Our ref: DOC19/771366-1

Your ref: SSD 9827

**Biodiversity and Conservation Division Review of Environmental Impact Statement –
Horizon at Lee 5 Mixed Use Development (SSD 9827)**

Horizon at Lee 5 Mixed Use Development– Environmental Impact Statement

Basement Level 01

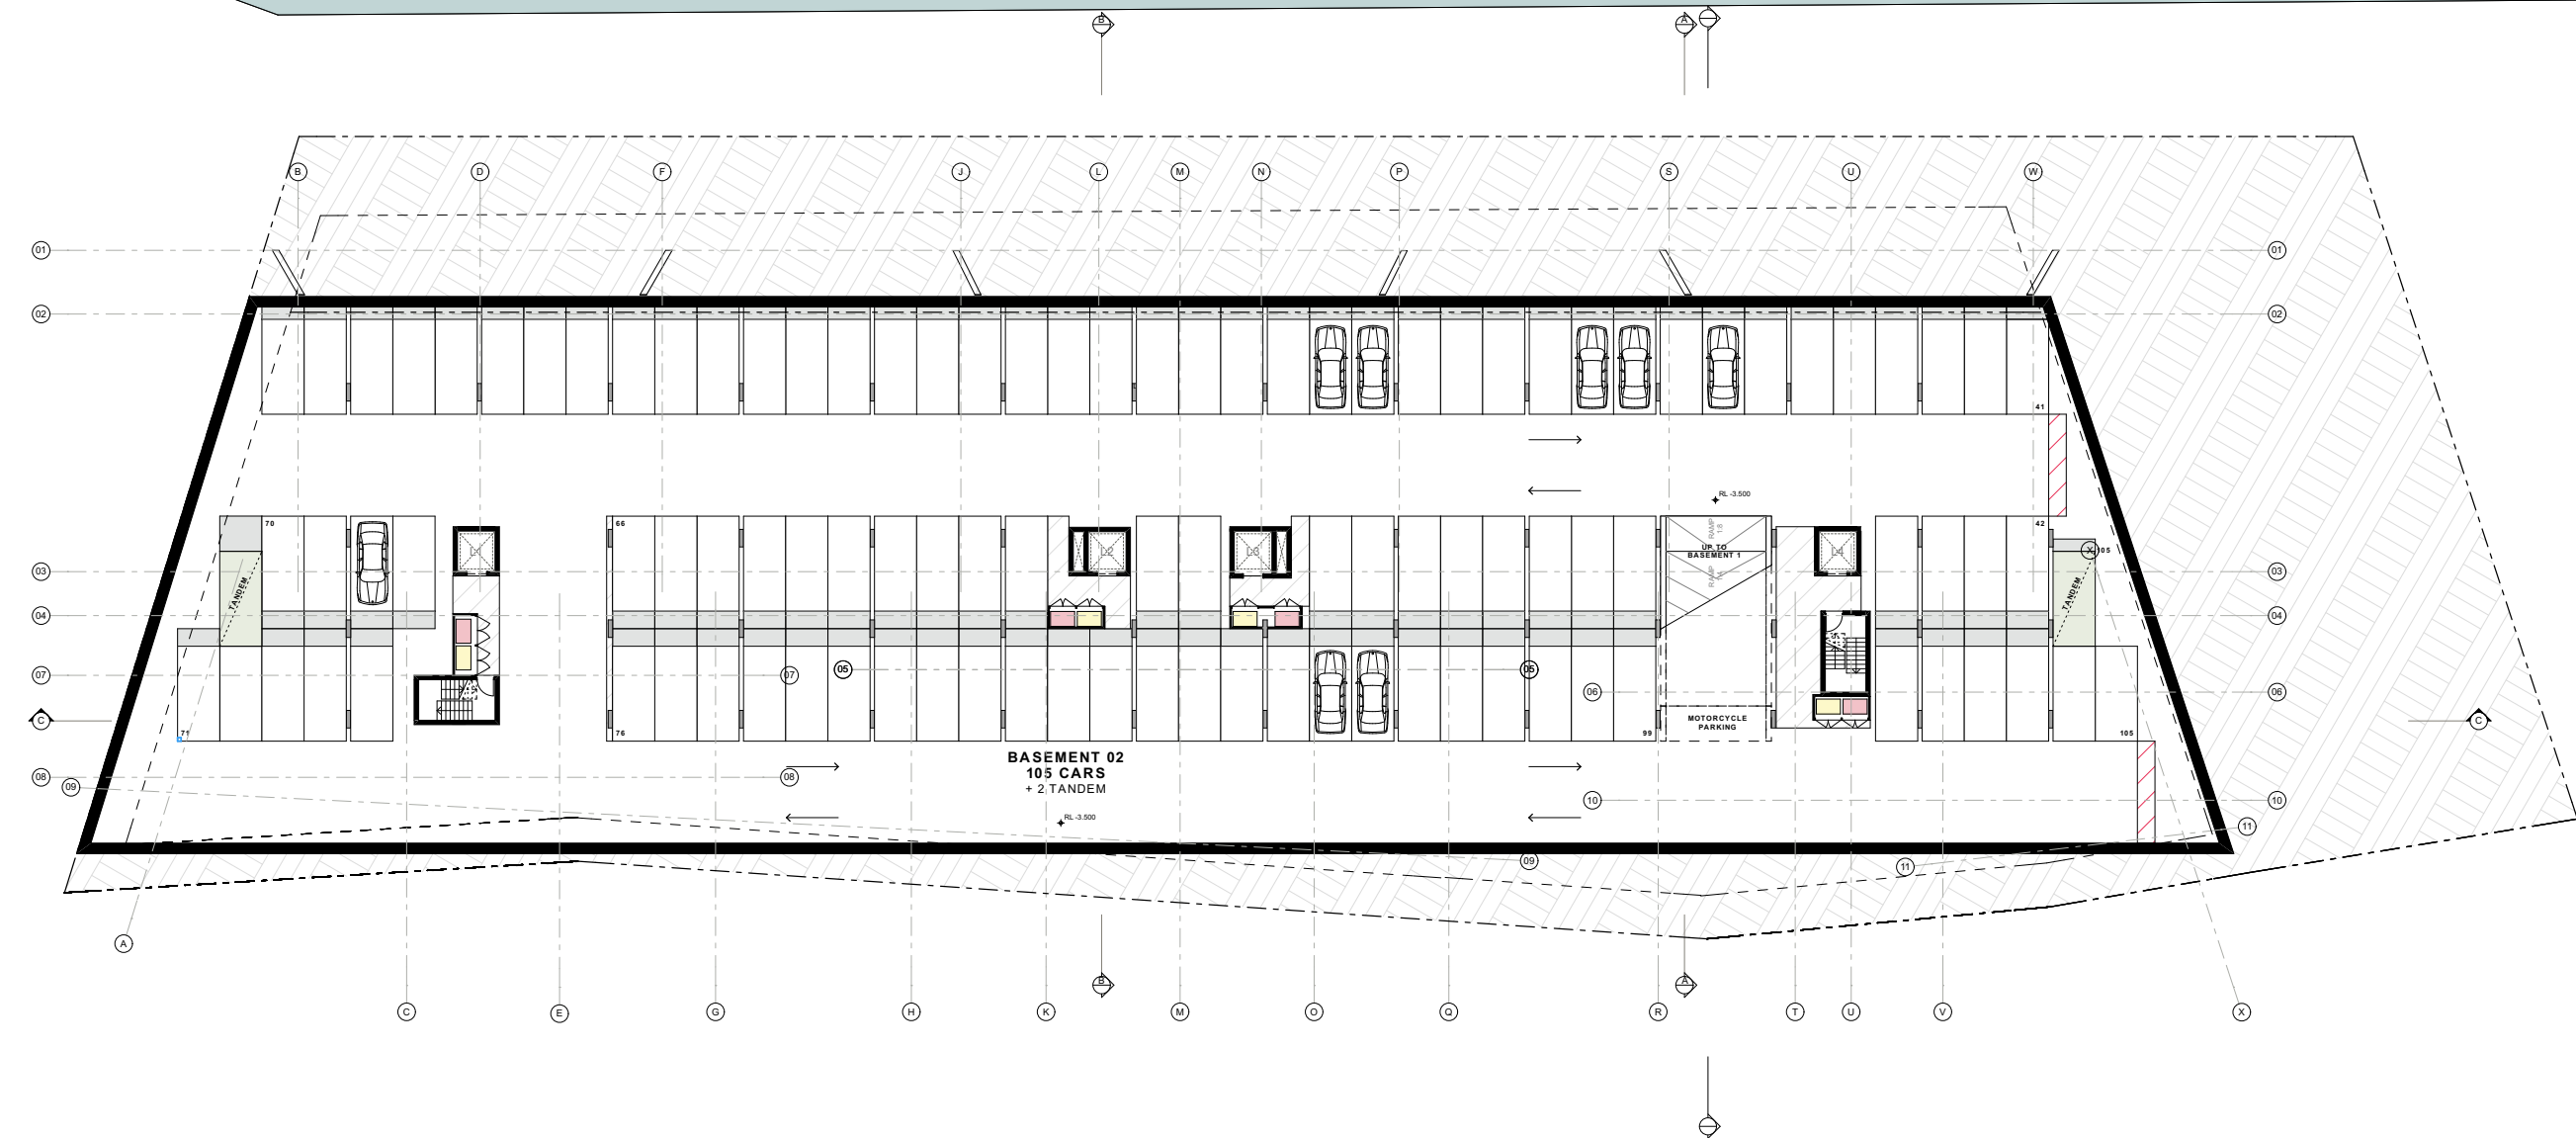
1. The information provided is insufficient to adequately assess the egress from the underground carpark to the flood refuge

The Flood Risk and Impact Assessment (Northrop 2018) does not address the flood risks in the underground car parks. During rare flood events, the car parks will be inundated and extremely hazardous. People trapped in the carpark will need to evacuate via internal stairwells. However, there is the potential that people will not be able to access the stairs if the stairway doors are locked or if there is a significant build-up of hydrostatic pressure against the doors. No information has been provided on how this risk will be managed.

Recommendation 1

The proponent demonstrate that the underground car park can be safely evacuated during an extreme flood event.
